SPR EA1N and EA2 PROJECTS

DEADLINE 6 – COMMENTS ON EAST ANGLIA ONE OPERATION PHASE NOISE MONITORING REPORT SUBMITTED AT DEADLINE 5

Interested Party: SASES **IP Reference Nos.** 20024106 and 20024110

Date: 24 February 2020

Plate 1: Threshold of hearing (BS ISO 226:2003)

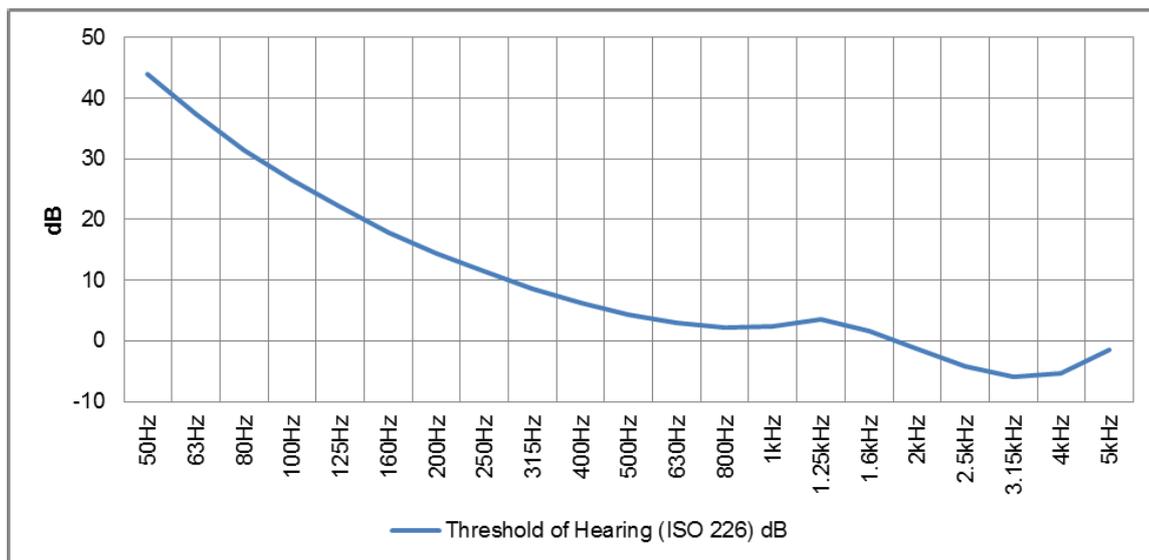
From the NANR116 report the EA1 report takes the outside-inside correction as a minimum of 19 dB and says that "On this basis, the spectral level of a 100 Hz tone in the specific sound from the substation that is no greater than 42 dB $L_{eq,100Hz,outside}$ may be approximately 19 to 25 dB $L_{eq,100Hz,inside}$ ". The report then compares this with the threshold of hearing from ISO 226 which it takes as 26 dB at 100Hz (for 50% of the population¹). Thus, on this basis, 42 dB (without A-

¹ The report misquotes the definition of audibility from ISO226 which should be "3.7 threshold of hearing level of a sound at which, under specified conditions, a person gives 50 % of correct detection responses on repeated trials"

weighting) outside gives $42-19=23$ dB inside, 3dB below the 50% audibility threshold.

If the DCO Requirements 26 and 27 limit is an A-weighted level of (as now proposed) 31 dBA, and if it should be tonal such that all the spectral content was at 100Hz, this is a physical sound level, after removing the A-weighting, of 50.1 dB. After taking the outside to inside reduction of 19 dB this gives an internal sound level of 31.1 dB for comparison against the audibility threshold of 26 dB. It will therefore be highly perceptible (over 5dB above the 50% audibility threshold).

East Anglia ONE Offshore Windfarm

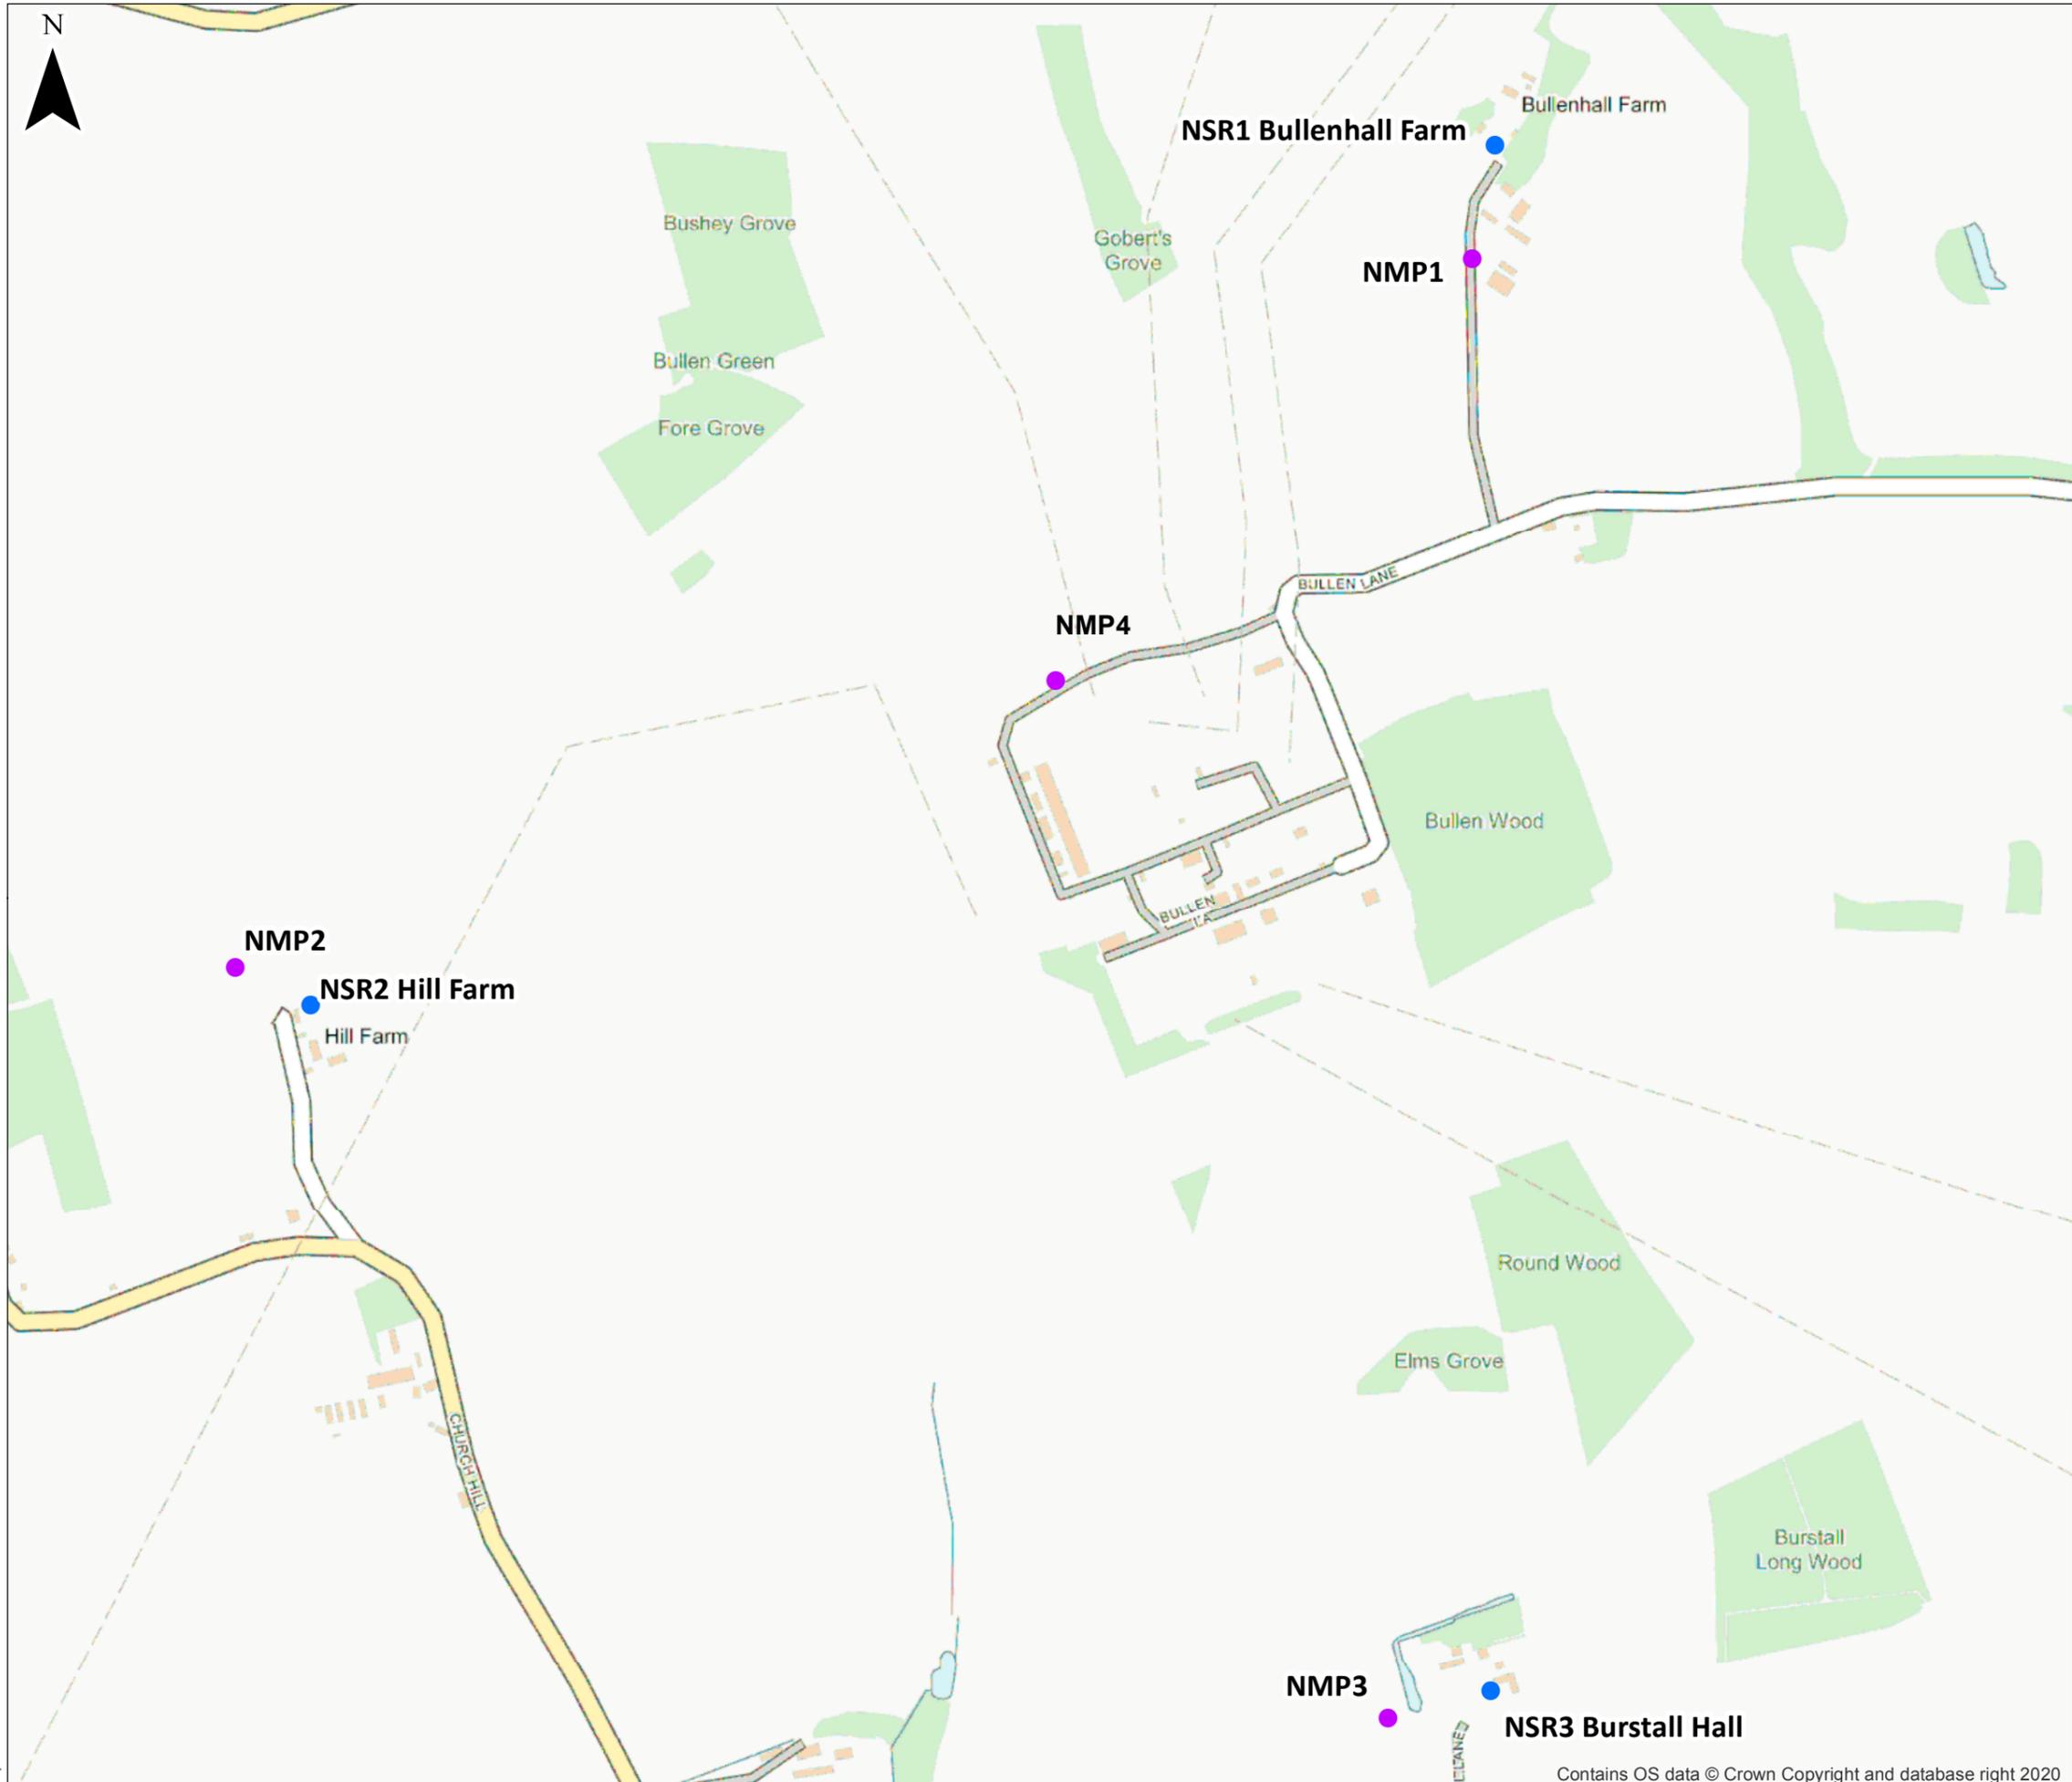
20. The plan attached to the EA1 Report (reproduced at Appendix 2 below) shows the location of the three receptors. This plan is unhelpful as it does not show the position or layout of the EA1 substation at Bramford. What is more informative is Figure 26.2 from the EA1 Environmental Statement which is reproduced at Appendix 2 below accompanied by the relevant link.
21. These plans show that the monitoring points for EA1 are 600m to 1200m from the EA1 substation whereas those proposed for Friston are approximately 250m from the substations, with the village of Friston in close proximity.
